DISCHARGE OF CONDITION REF:3/2024/0711

Approval of details reserved by conditions 5 (Estate Road Details), 6 (Estate Road Management), 8 (Off-site highway works) and 9 (Construction Management Plan) on planning permission 3/2022/0966 **Crow Trees Farm, Crow Trees Brow, Chatburn, BB7 4AA**

Condition 8 (Off-Site Highway Works)

Drawing Title: Proposed Sign Arrangement

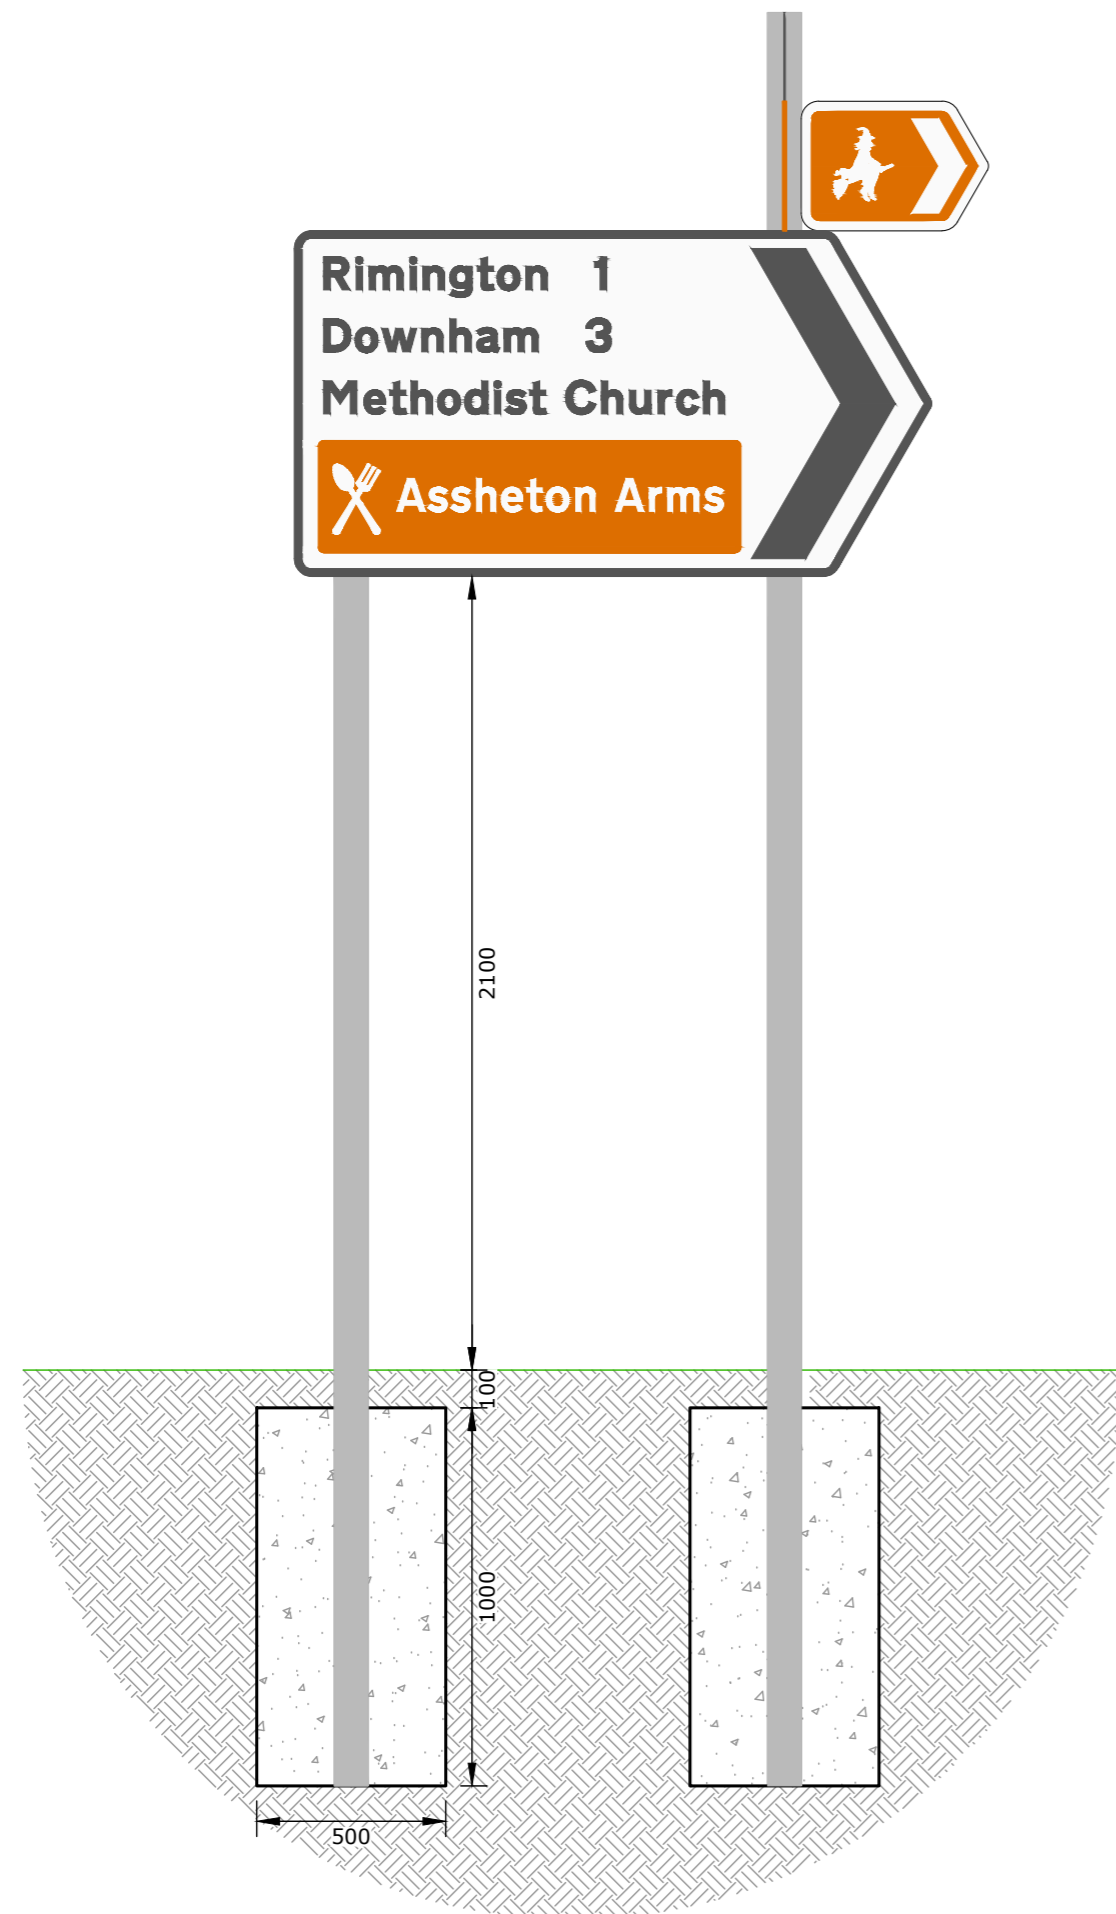
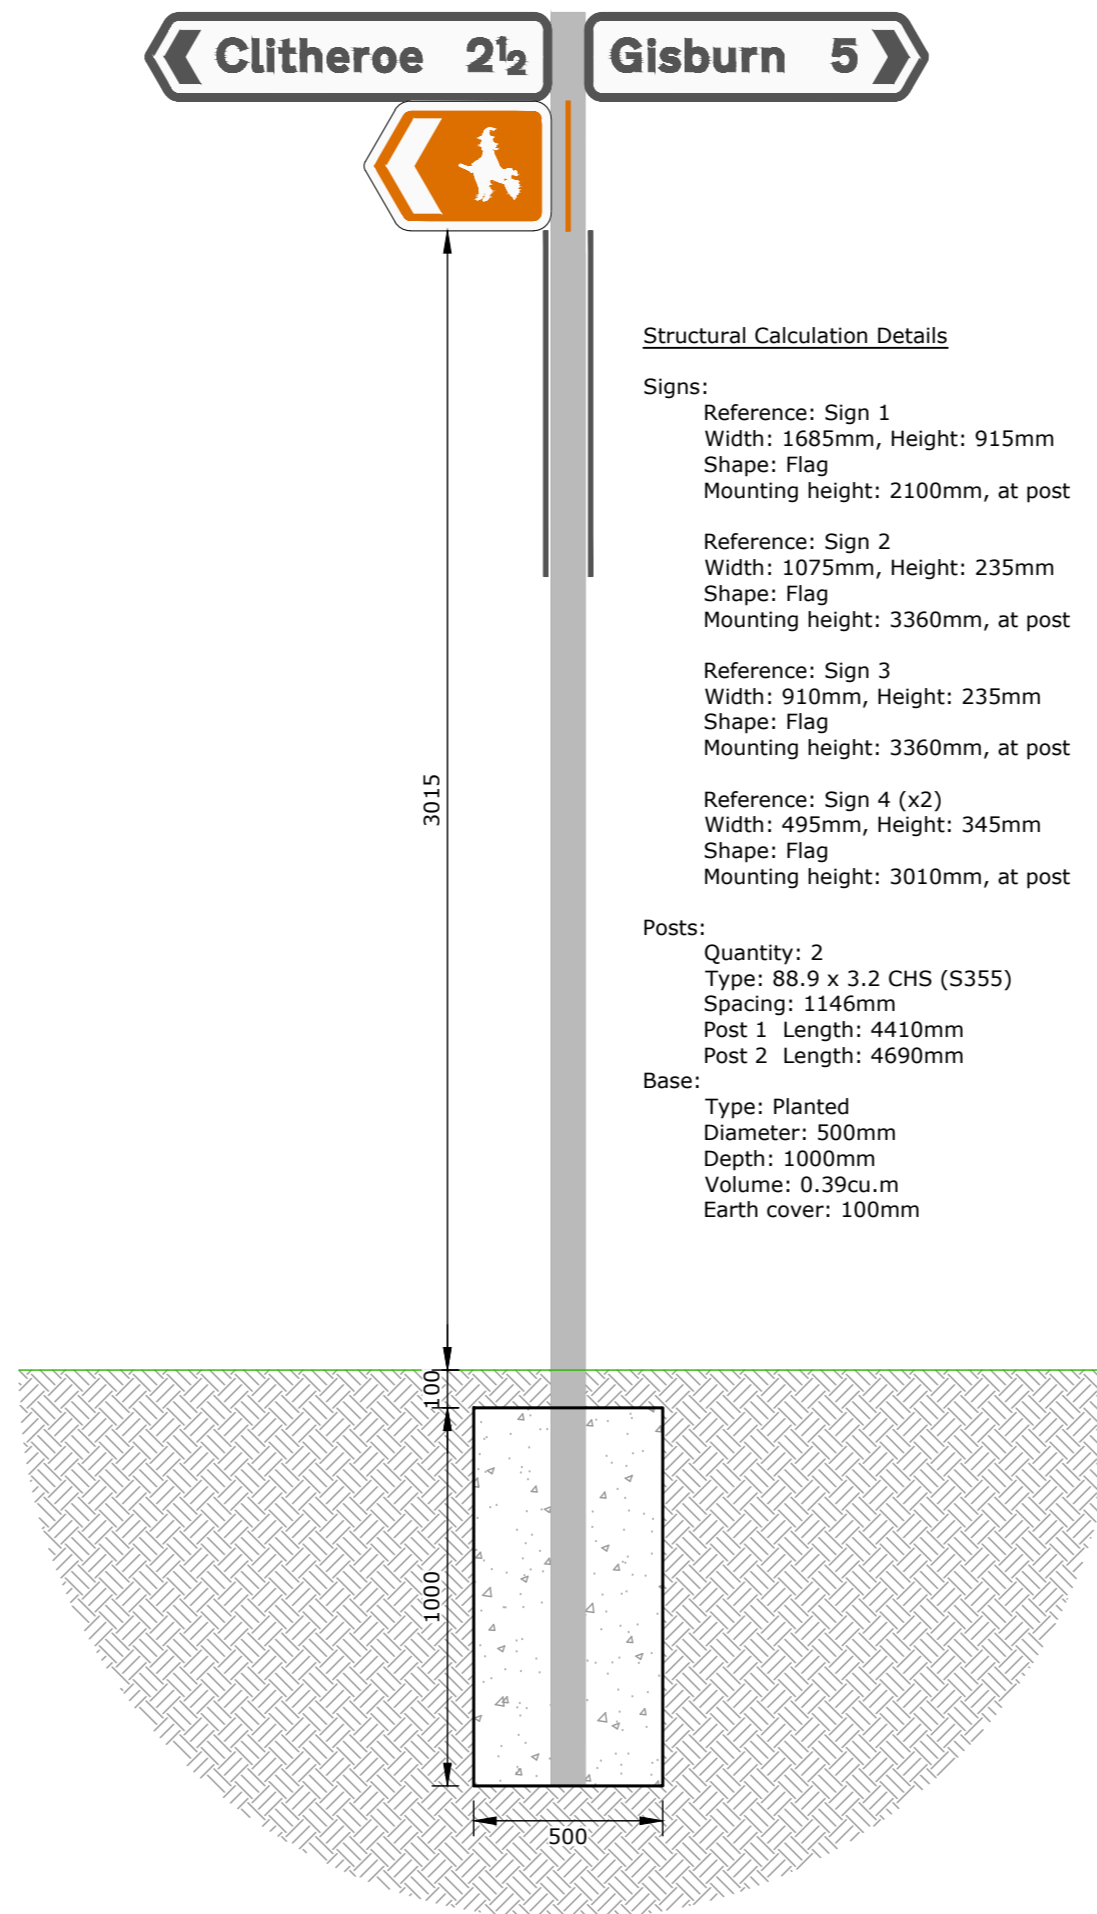
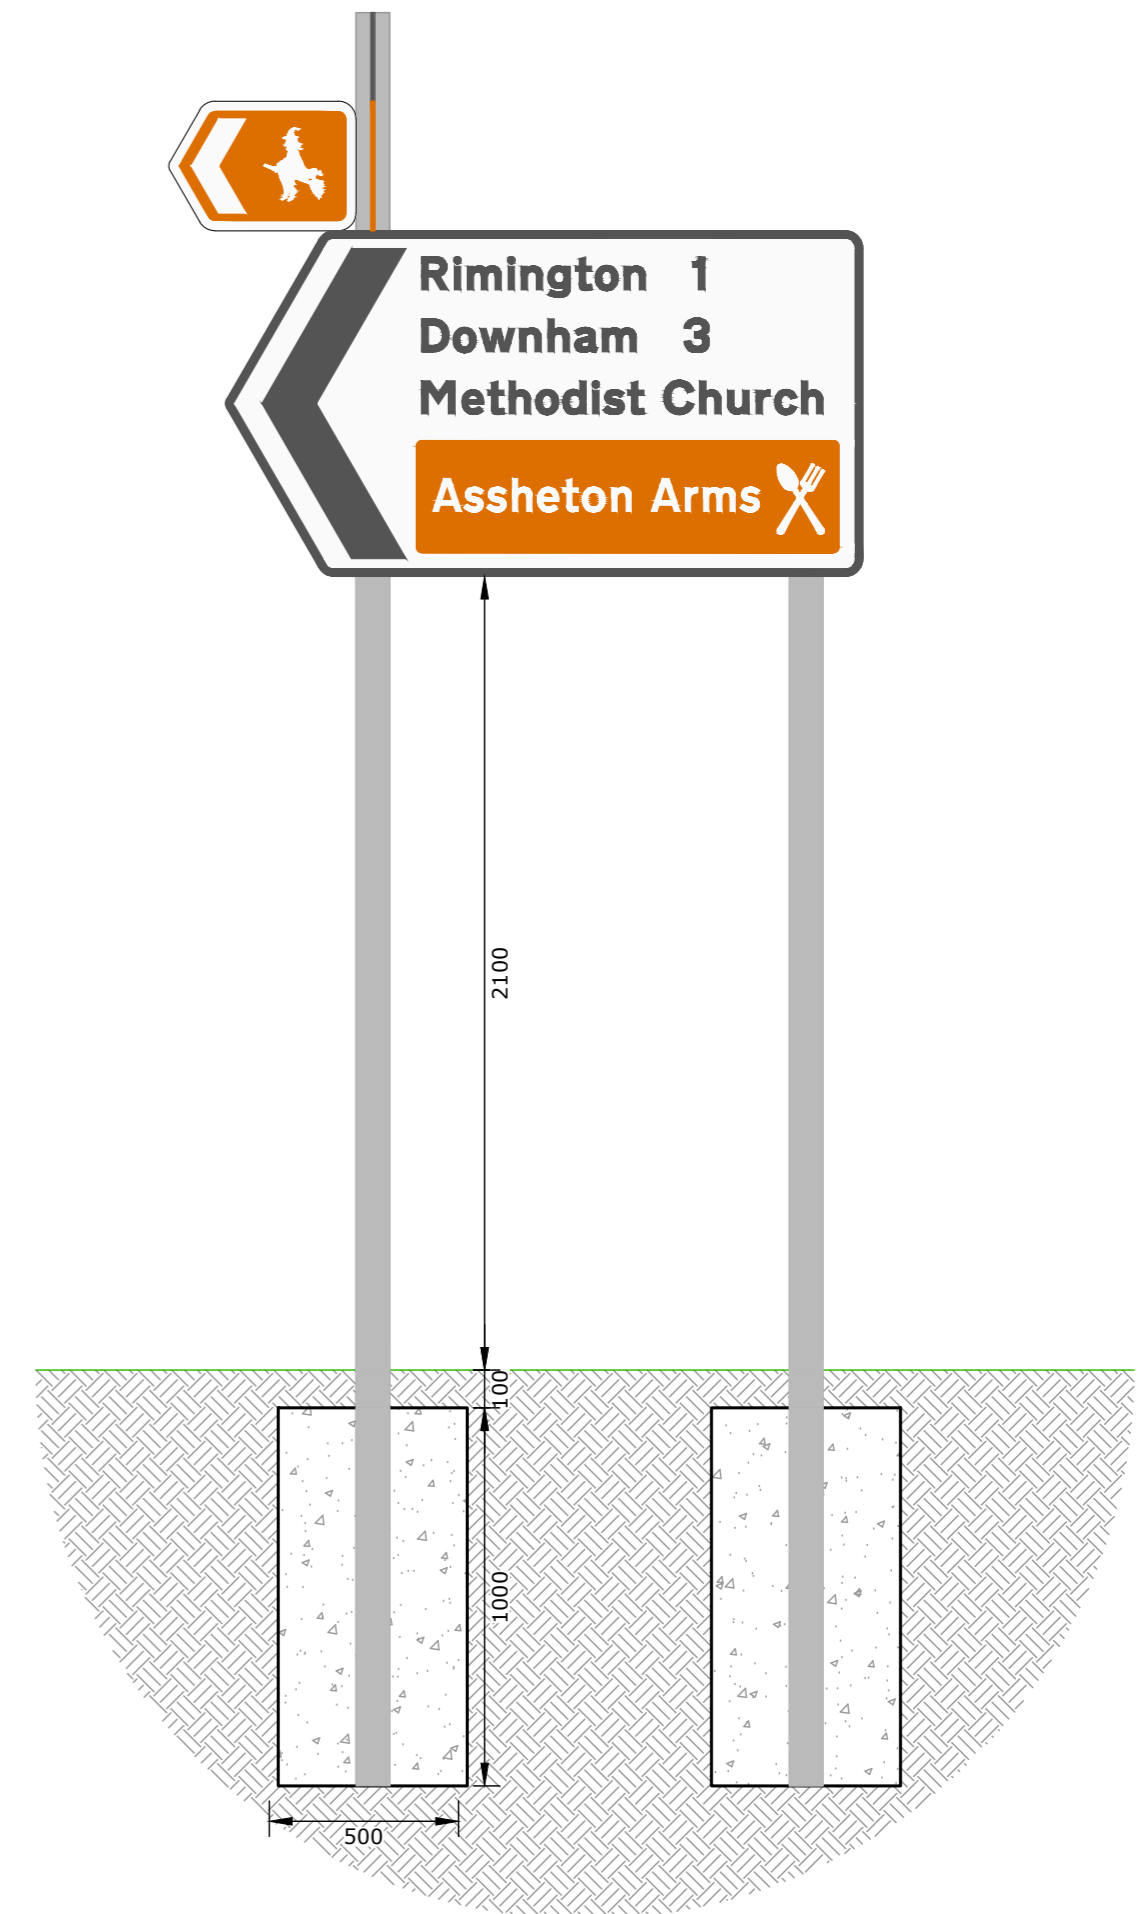
Following Lancs CC Highways release of Pendle Witch brown directional signage, the proposed off-site signs to the site development have been updated to include this sign, as illustrated on the now provided sign detail ref K39346-10B Proposed Sign Arrangement.
